From: Planning
Subject: FW: 3/2023/0221 Lower Barn Farm Whalley Road Sabden Lancashire BB7 9DT

Reference 3/2023/0221
Location Lower Barn Farm Whalley Road Sabden Lancashire BB7 9DT
Proposal Proposed field mounted 20kwp solar pv array (52 new solar panels).

PROPOSED SECTION AND PLAN

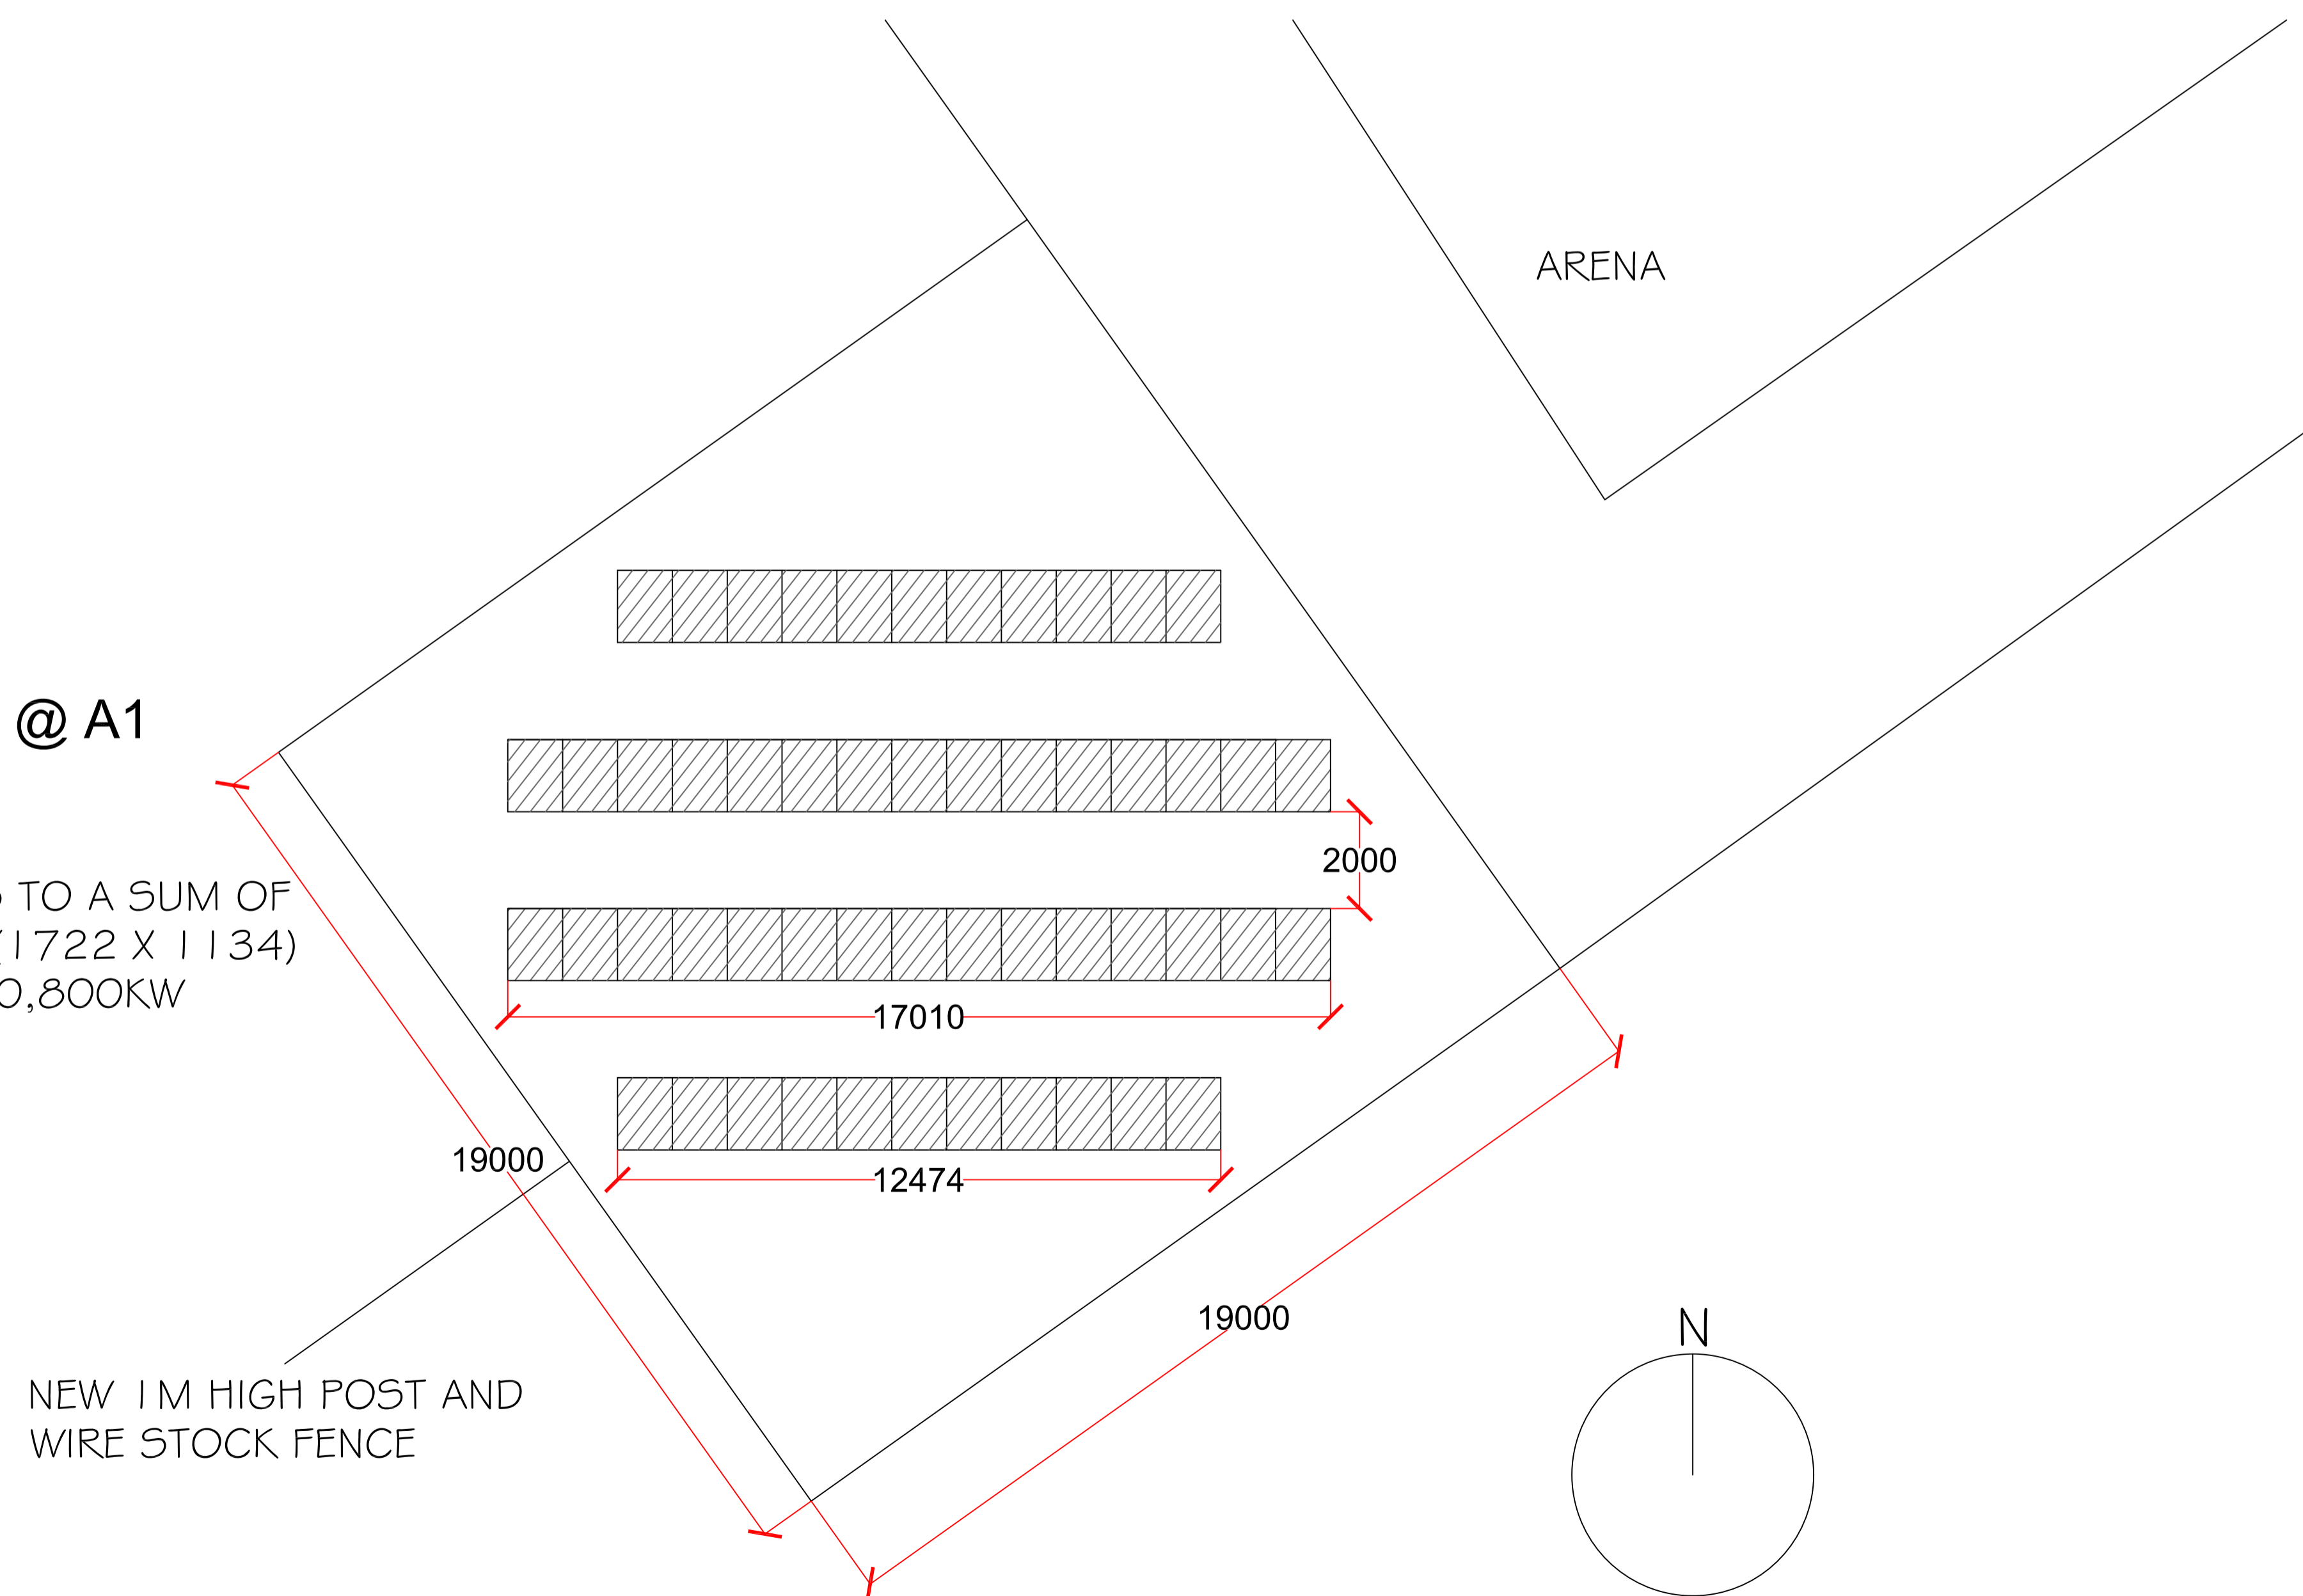
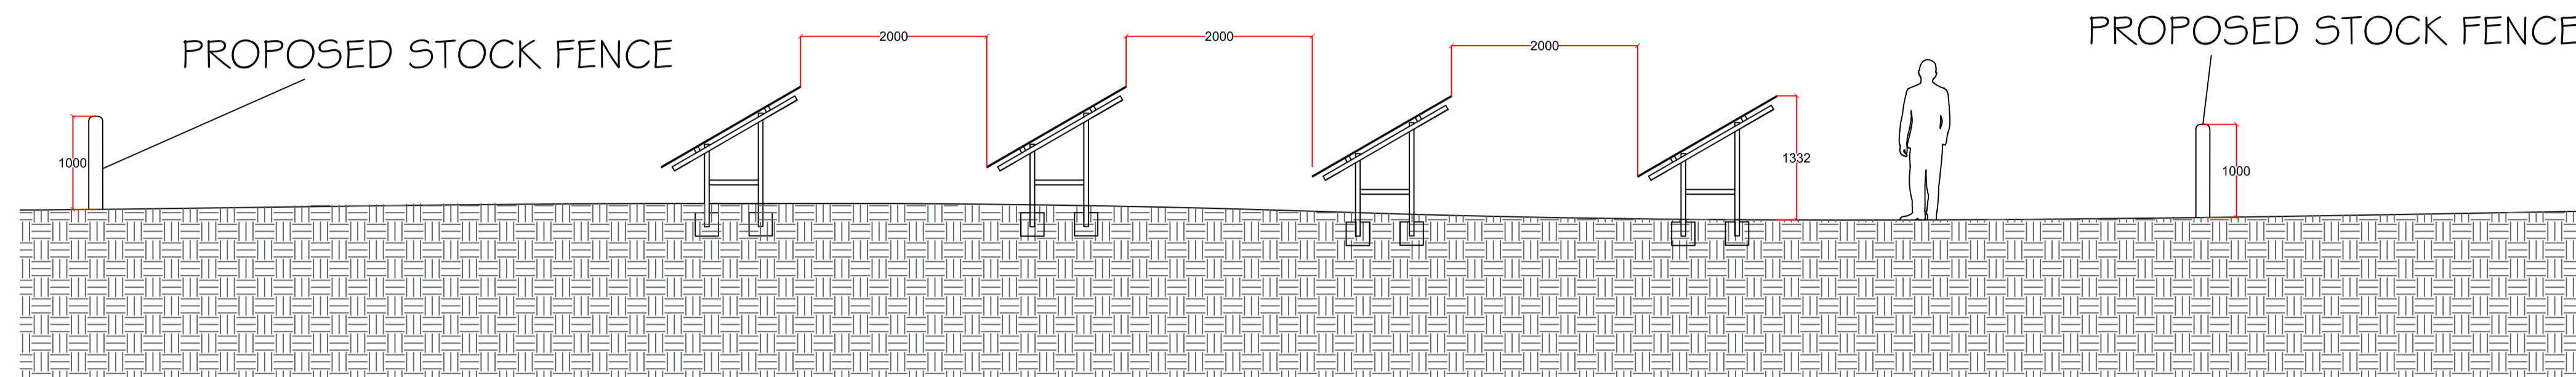
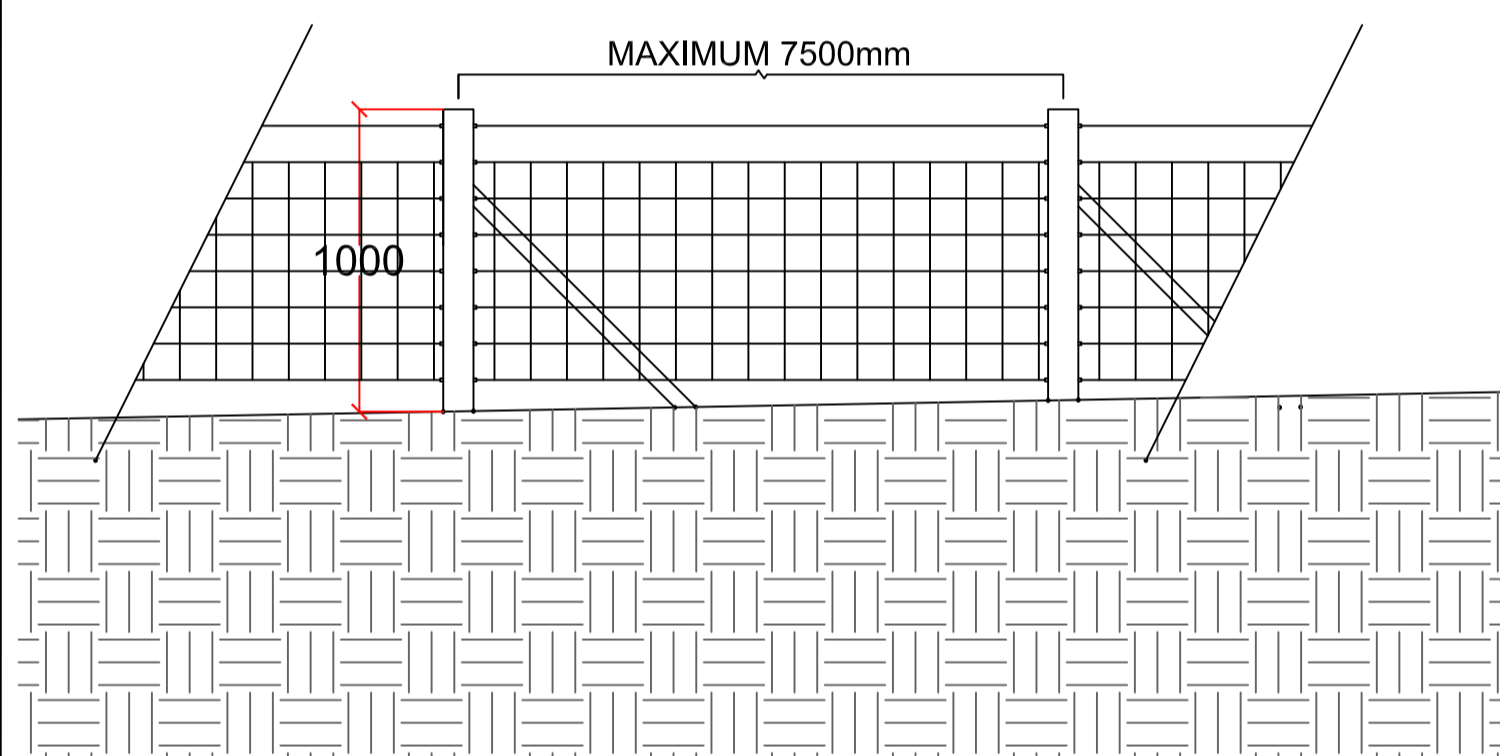
The developer is advised that the proposed solar panels will obstruct footpath FP0337113 triggering a Diversion Order under the provisions of the Town and Country Planning Act 1990 Section 257 (TCPA90 S257). TCPA90 S257 orders are administered by the authority that is considering, or has granted the planning permission, in this instance Ribble Valley Borough Council.

The detail of the exact alignment of the new route, the construction specification and any association works would need to be agreed with public rights of way before the necessary TCPA90 S257 Order is made. I can advise that the new route must have a minimum width of 2 metres, have a properly constructed surface with no gates or stiles crossing the new route.
